## Engineers Comments Regarding Surface Water Drainage

<b>Application Reference:</b>	BN/125/25/PL	<b>Reviewer Reference:</b>	ADC/EXT4b
<b>Planning Officer:</b>	Amber Willard	<b>Date of Review:</b>	26/01/2026
<b>Site Name:</b>	Land South of The Hollies 84 Barnham Road Eastergate PO22 0ES		
<b>Application Description:</b>	Construction of 2 No. dwellings (C2 Residential Institutions), in association with the Hollies, and associated works. This application affects the setting of a listed building and is in CIL Zone 2 and is CIL Liable as new dwellings.		
<b>Assessment Number:</b>	1 of 2

7.2 **Appendix B – Drainage Layout**

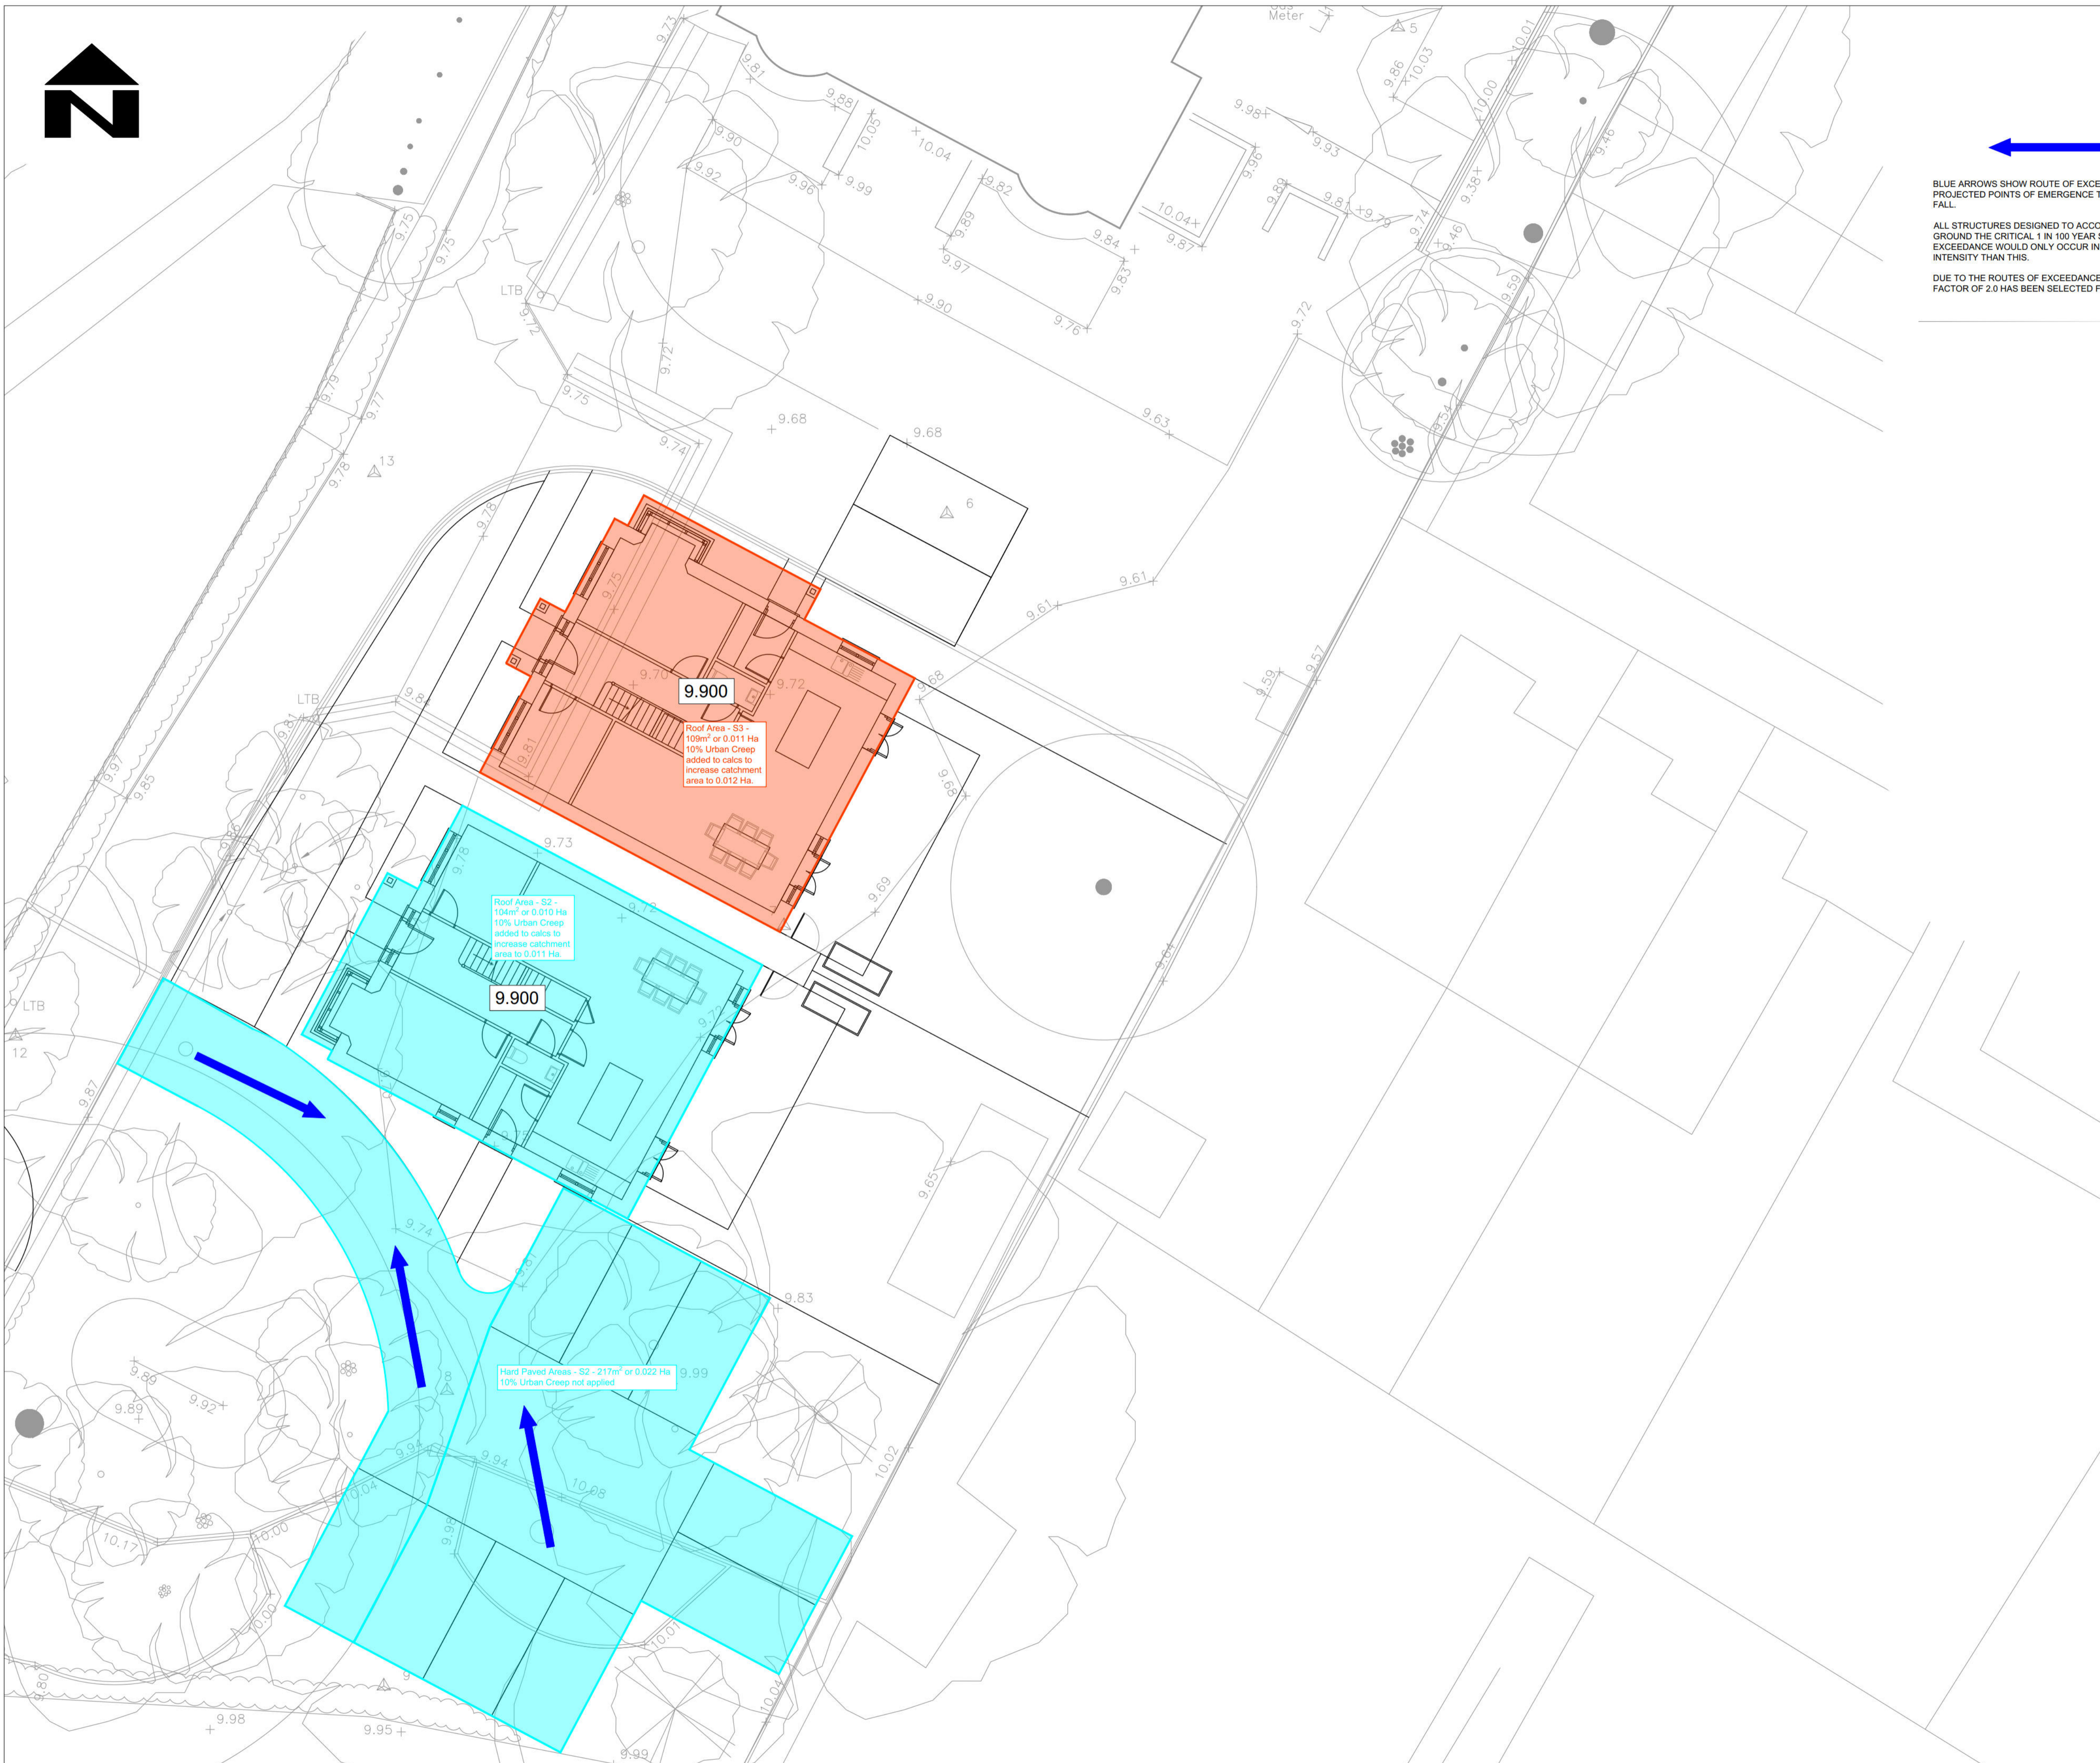
- 3.3. Contributing areas do not appear to have been accurately modelled, with the area for roof area S2 rounded down. The footpaths to the properties and the patios are also not included. A justification for not including pervious areas has not been submitted.

- 3.4. The node S3 cover level appears to have been modelled incorrectly. The plans show that the cover level should be 9.610, whereas it is set at 7.50 in the model. The invert level of 8.210 is the same on both the plan and the model. This is important as the model shows no flooding on the critical 1%AEP + CCA event with a water level of 9.689m. If the cover level had been 9.610 (as per the plan) then this would show as flooding. When modelled correctly the system may need further storage, it is unclear what capacity may be required or where it may be stored. If the system floods on this event then the designer must show that the flooded volume can be safely contained on site without increasing flood risk.

- 3.5. The connection to the existing surface water sewer relies on crossing third party land. Agreement in principle from the landowners has not been submitted. Similarly, the cover level and invert level are quoted on the plans without the supporting manhole schedules from Sothern Water or surveys to corroborate the levels. This is important to demonstrate that pumping is not necessary.
